Your Ref: OWPC24580
Our Ref: LU/297/19/PL 26-09-2019
Please ask for:
Zac Denton

1 No. new dwelling (resubmission following LU/84/19/PL).

Land to rear of 141 Wick Street Littlehampton

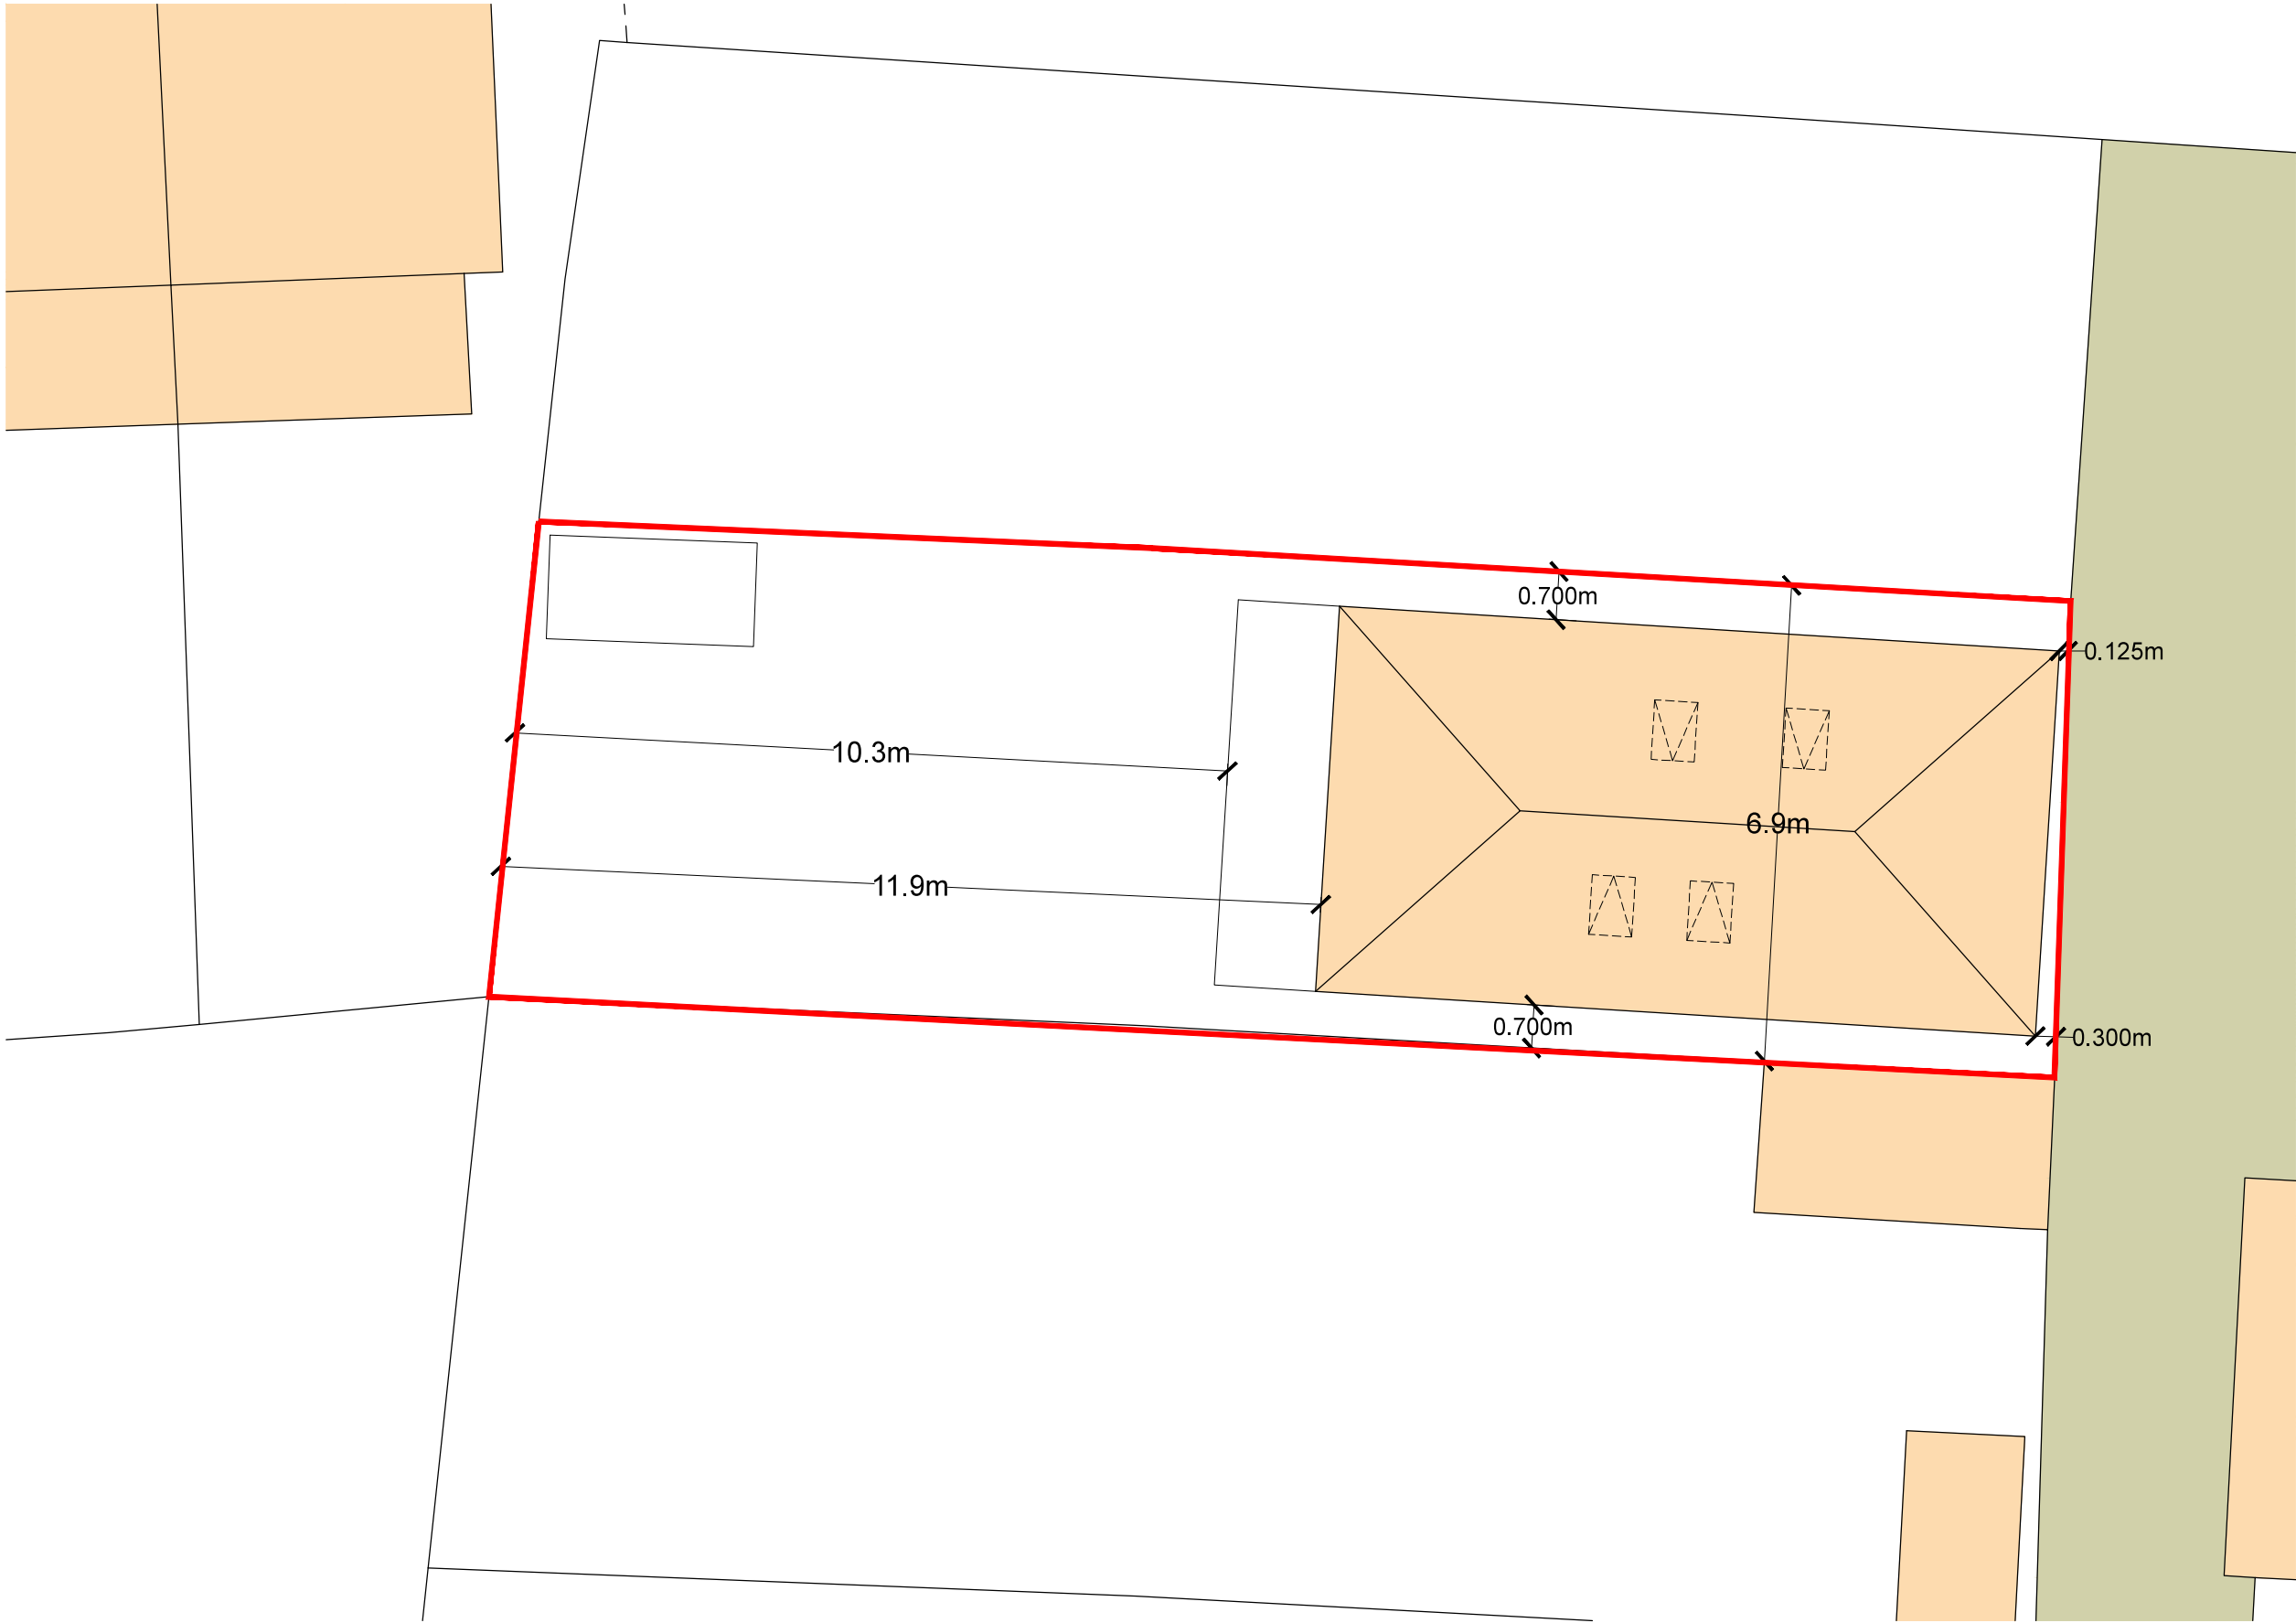
The current application does not show any provision for the turning of a vehicle within the site.

The access to the 'site' is through an existing arch way between two existing shops, it is the only access to the rear of the 4 properties that have the shared access. We need 24 hour access to the rear of our property (STS Communications) for our company vehicle as well as our customers vehicles and our own private vehicles, if this property is built and the residents do not park in their garage or leave bins etc.. outside the front of the property (maximum 300mm space between the front of the dwelling and the shared vehicular access to our property), this will cause access problems and will be disruptive to our business.

141 Wick Street has already been granted permission (Application LU/16/17/PL) to build a single storey building at the rear of the shop, if permission is granted for the new dwelling, the area at the back of the properties will be 'built up' to the extent where it will become more difficult to gain the access that we require.

Ground Floor
Scale 1:100 @ A3

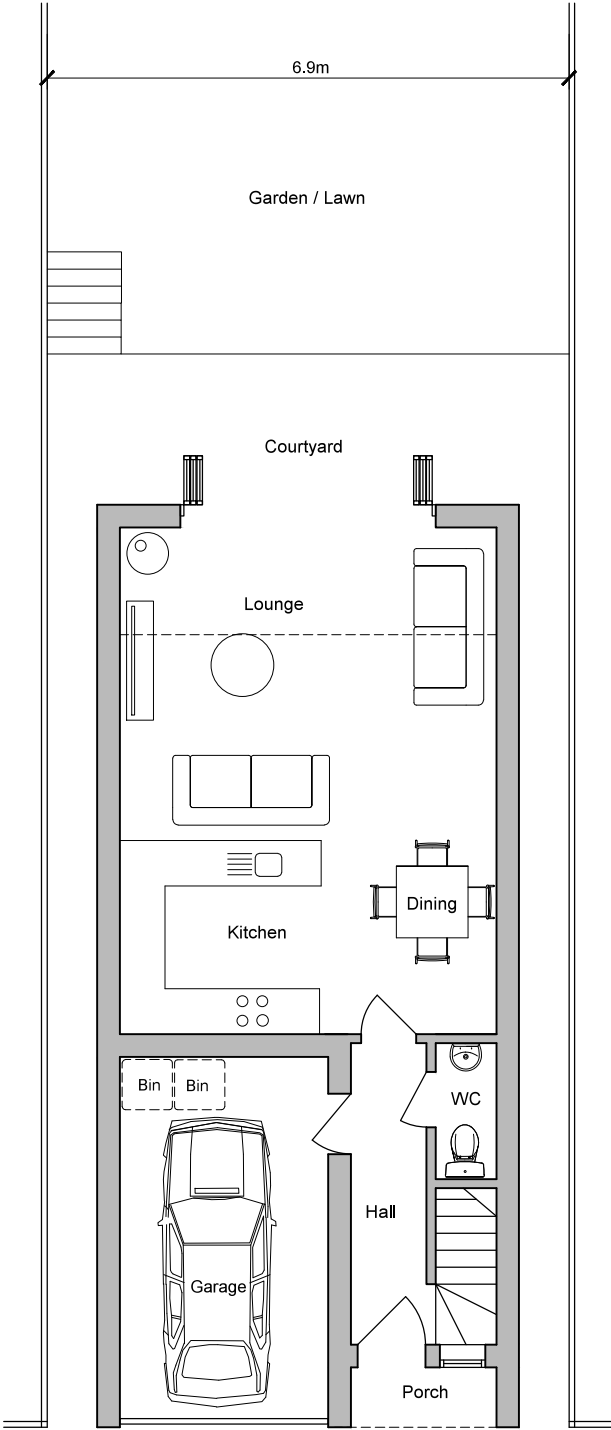
With regards to parking, the proposed application shows a single garage built into the front of the dwelling. Referring back to a previous application that was submitted in 2000 (and renewed in 2005) for a double garage with a one bedroom flat above, that was approved conditionally (Application LU/204/00/ and a renewal application LU/227/05/), one of the conditions set out in the decision by your planning officer is, Condition 3 "The building hereby permitted shall not be occupied until space has been laid out within the site in accordance with details approved by The Local Planning Authority for the turning of vehicles clear of the public highway and such space shall not thereafter be used other than as a turning area", Reason: In the interests of road safety.
